Recommendation Report

P/37/13/CLP.

Re: 4 The Green, Pagham

EXISTING ELEVATIONS (1/100)

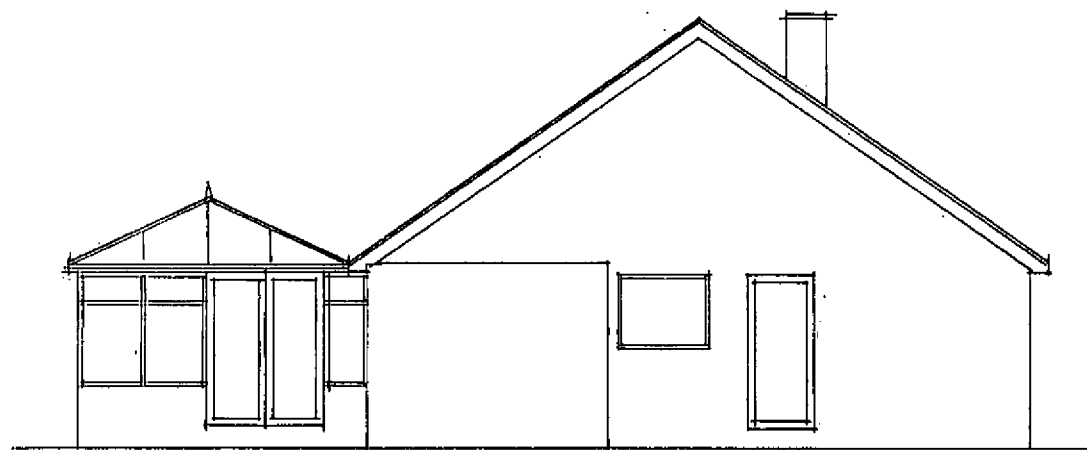
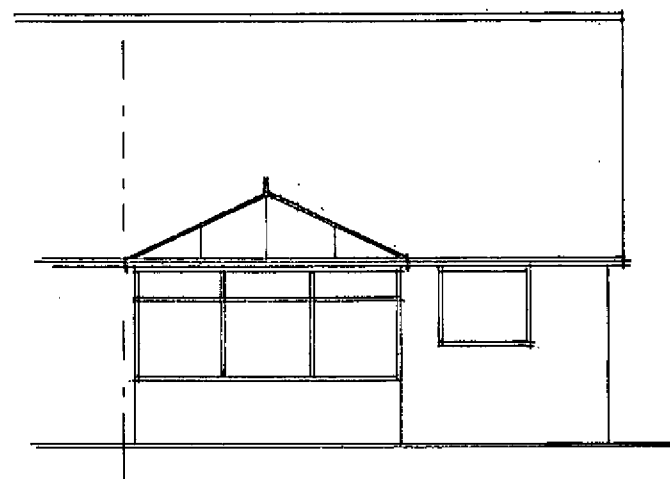
Thank you for your email, unfortunately the existing and proposed rear elevations do not accord with the floor plans provided, could you amend these and then re-send accordingly.

The ext pro rear
elevations do not
accord with the
floor plans
provided

Revised rear elevation attached (existing and proposed).
